Planning Application Ref: R/248/17/T

Location: rear of 10-12 Bushby Avenue, Rustington

Description of works: Prune back in line with boundary wall of No 7 Waverley Road and crown lift to 5.5m to 6m and remove basal suckers on 1 No Sycamore tree

a) ATTACHMENT 1 - PLAN.

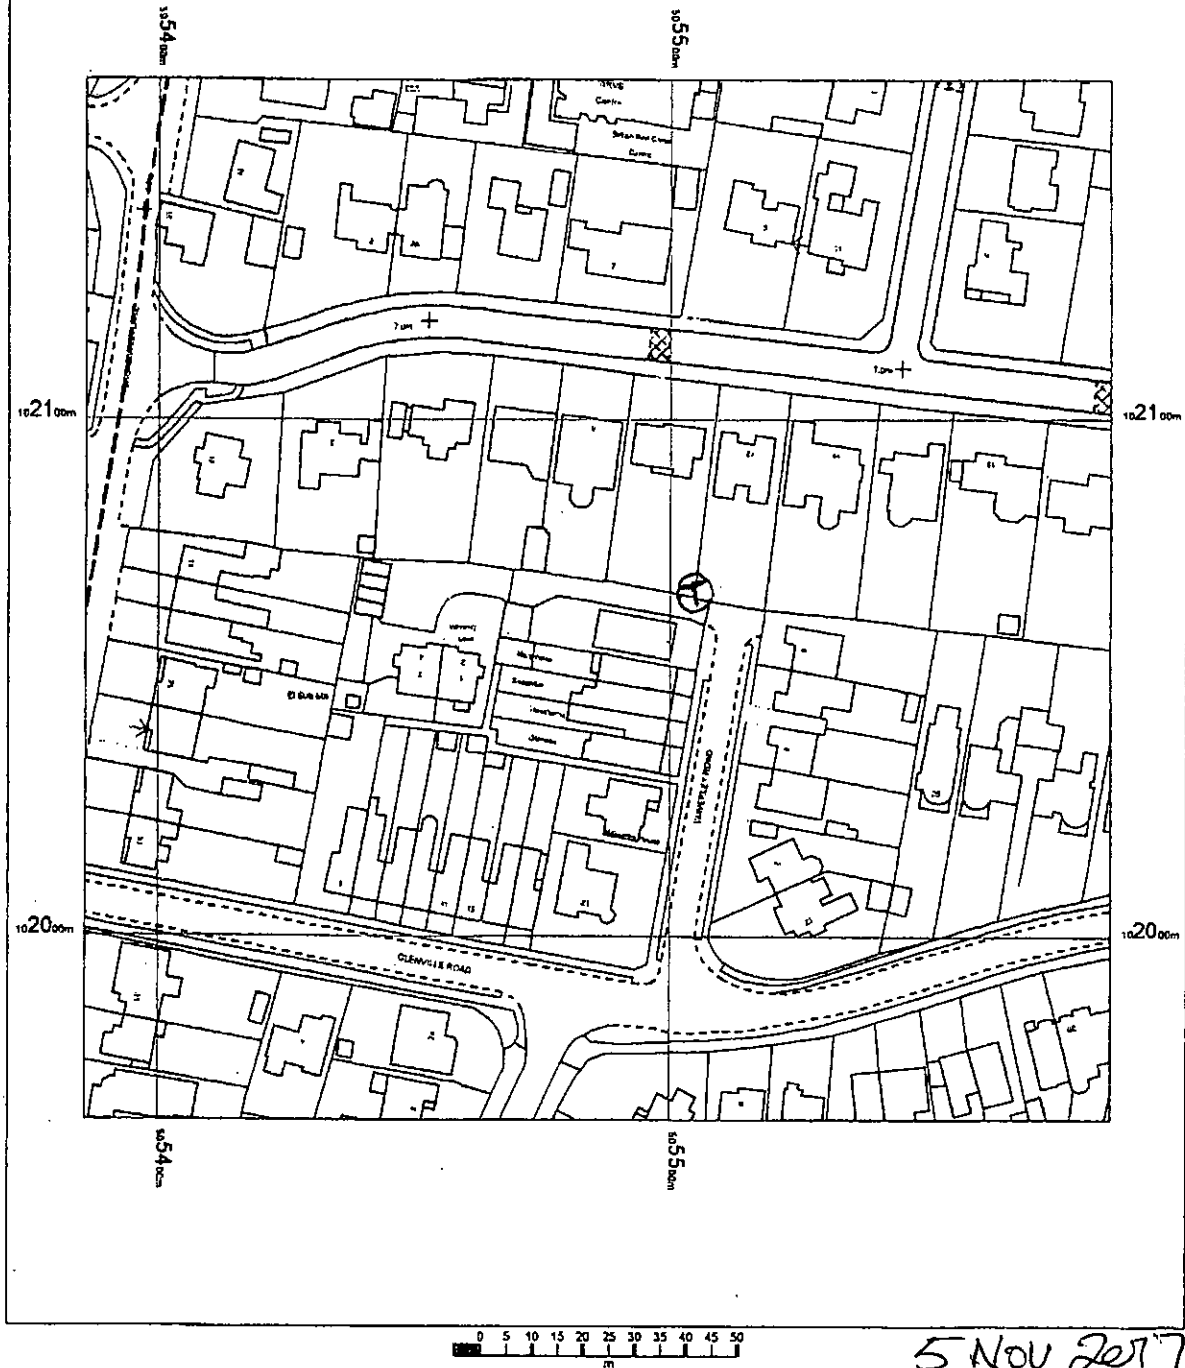
- The request to remove the overhanging growth back in line with the boundary wall of No 7 Waverley is excessive and would be harmful to this trees visual amenity value in the landscape and also not comply with BS3998 recommendations.
- The tree already has a ground clearance to almost 6m from ground above the access drive.
- The basal suckers are a nuisance issue and may be removed.

- I recommend **APPROVAL but ONLY for the removal of basal suckers and crown lifting to a maximum ground clearance of 6m.**
- I recommend **REFUSAL** for the shortening back of lateral spread as requested by the applicants.

- Where branches are to be shortened back the final cuts are to be made at the correct angle shown in BS3998:2010 and adjacent to a live bud or lateral.
